IMMINGHAM EASTERN RO-RO TERMINAL DCO APPLICATION

PINS REFERENCE TR030007

SUMMARY OF CASE MADE AT ISH2 BY DFDS

Image: ABP Environmental Statement: Volume 3 Navigational Simulation Study – Part 1, P48 [APP-90]

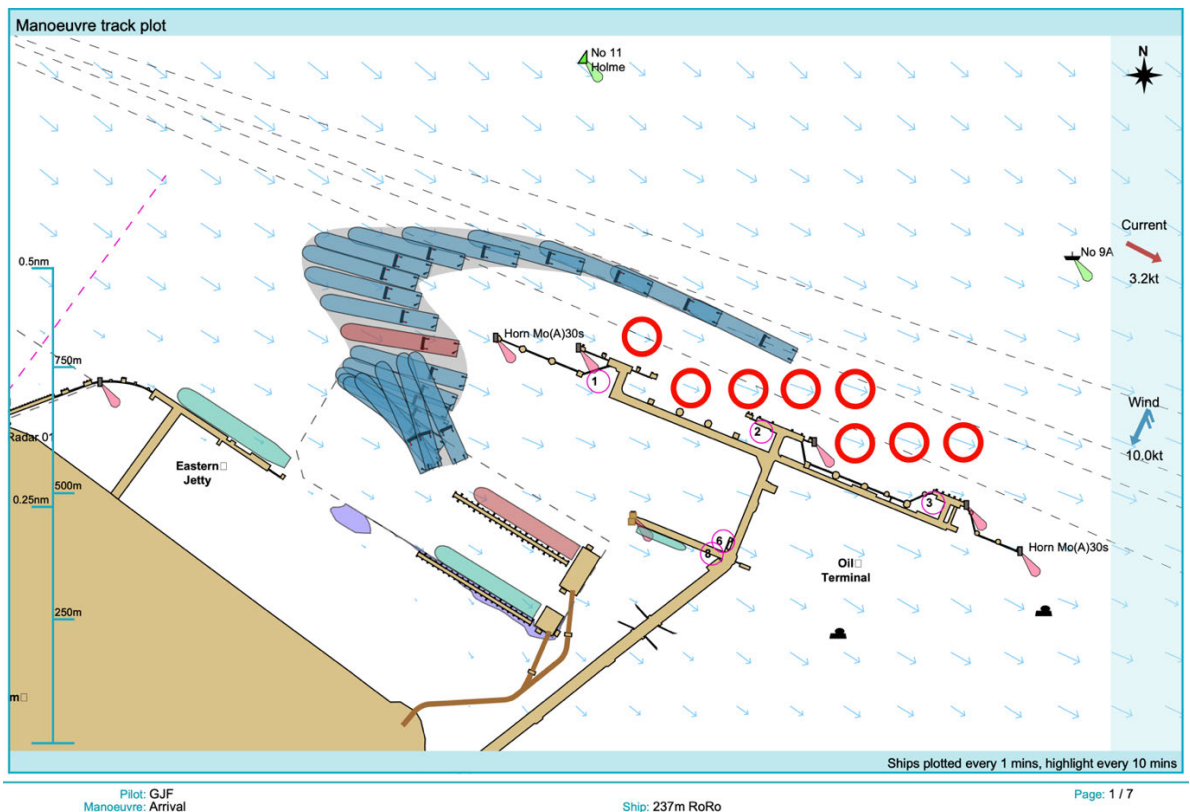
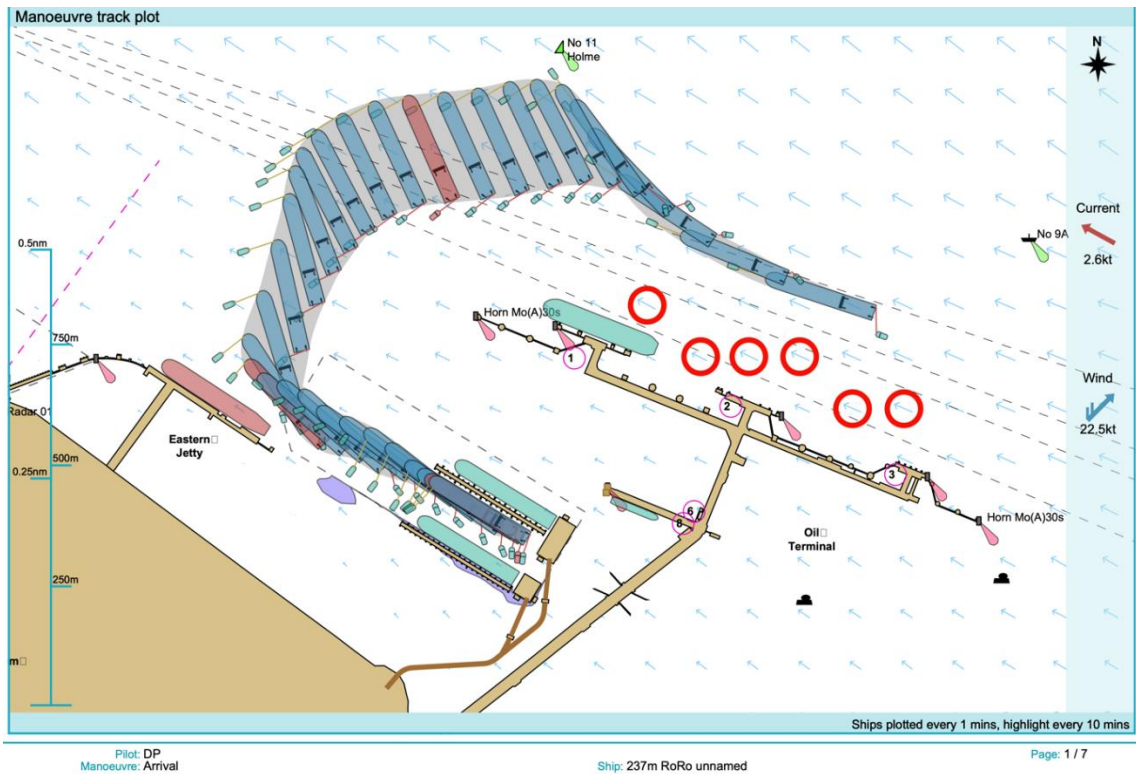
- 5.7 DFDS stated its concerns about tidal direction data in the simulations. The use of Applicant's buoy landward of the IOT is not disputed as DFDS have no data from this area, but the tidal direction seaward of the IOT is represented differently in the simulations to the practical experience of DFDS PEC (Pilot Exemption Certificate) holders. DFDS have suggested the Applicant takes a new reading north of the IOT as this affects vessels starting north of the IOT and their manoeuvres into these berths. The tidal direction makes a difference in how a pilot would approach the new berths, and the current could take a vessel on or off the IOT. DFDS have repeatedly raised concerns that the tidal data does not align with the experience of its pilots or with the Applicant's own guidebook. DFDS have also tried to engage with the Harbour Master expressing concerns about tidal data.
